# CITY OF PORTLAND, MAINE

October 11, 2017

Project Name: Onejoy Place Condominium - Twelve Unit Residential Building  
Project ID: 2017-103 (Subdivision and Site Plan)  
2017-128 (Conditional Use Inclusionary Zoning)  
Address: 1 Joy Place CBL: 045 E049001  
Applicant: Onejoy Place LLC  
Planner: Jean Fraser

LANDSCAPE PLAN

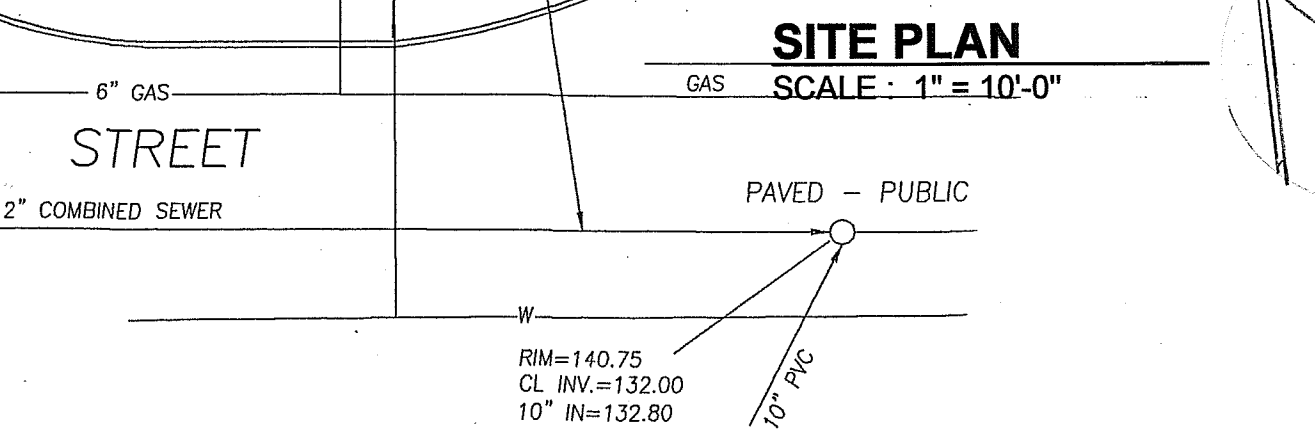
- v. That the Landscaping Plan shall be revised, for review and approval by the City Arborist and Planning Authority prior to the issuance of a building permit, to replace the Amur Maple with a species suggested by the City Arborist in his comments dated 9.21.2017; and

The project does have landscape challenges due to its unique site location and lack of street frontage. One suggestive comment would be to find a substitution for the Amur Maple as they tend to show up on the invasive plant list. Other suggestions might include 'Cornus mas', Hop Hornbeam, Cornelian Cherry Dogwood.

BRICK DRIVEWAY APRON

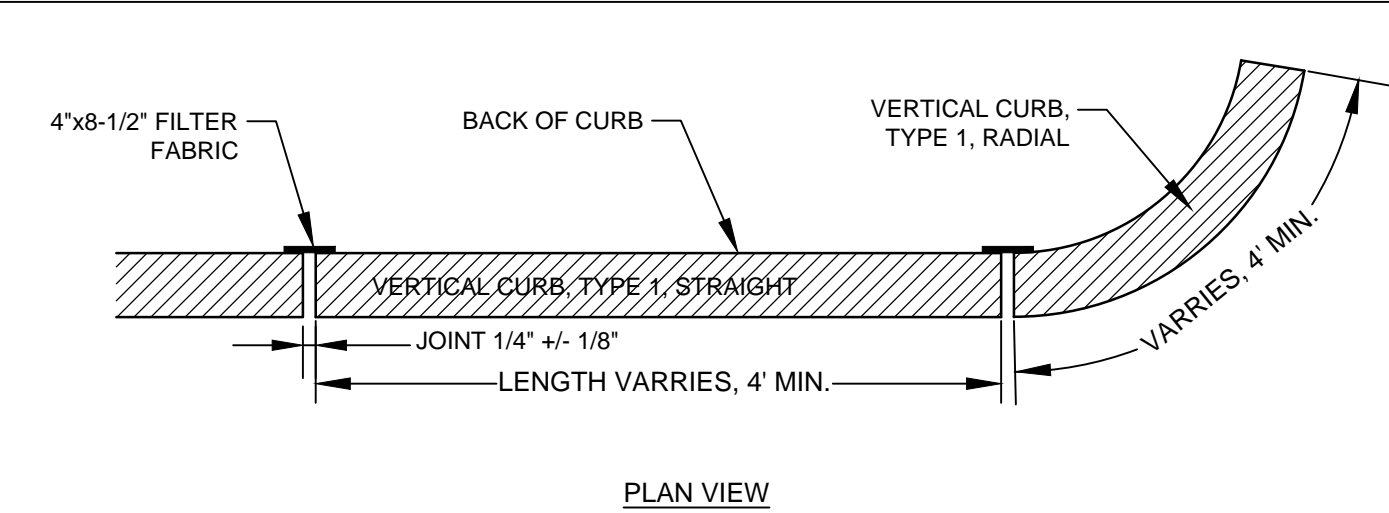
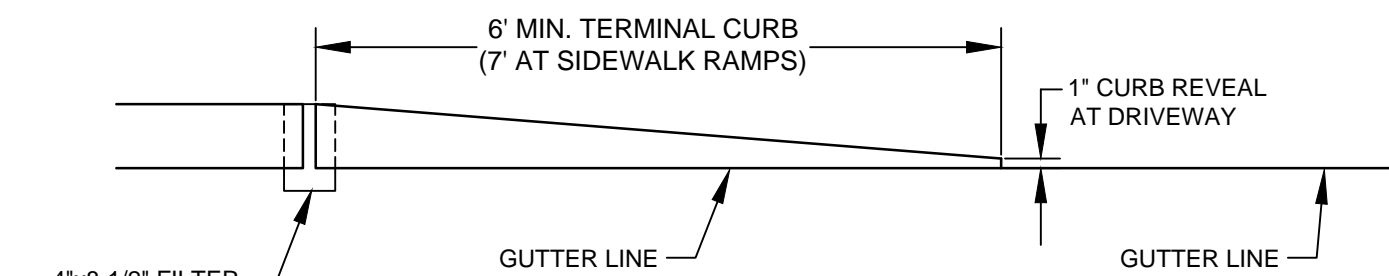
- viii. That the design of the apron and associated sidewalk shall meet Technical Standards and conform to the design detail provided in the final submissions (2% maximum cross-slope); and

- The driveway apron shall be designed to provide a maximum cross-slope of 2 percent along the pedestrian accessibility route.

**Status: The applicant has noted in writing that a 2 percent pedestrian accessibility route cannot be provided along Brackett Street in the Joy Place driveway apron area. The applicant has provided a driveway design detail that specifies a maximum cross-slope of 2 percent for the driveway apron. A condition of approval should reinforce the requirement that the driveway apron shall conform to the design detail provided (2% maximum cross-slope).**
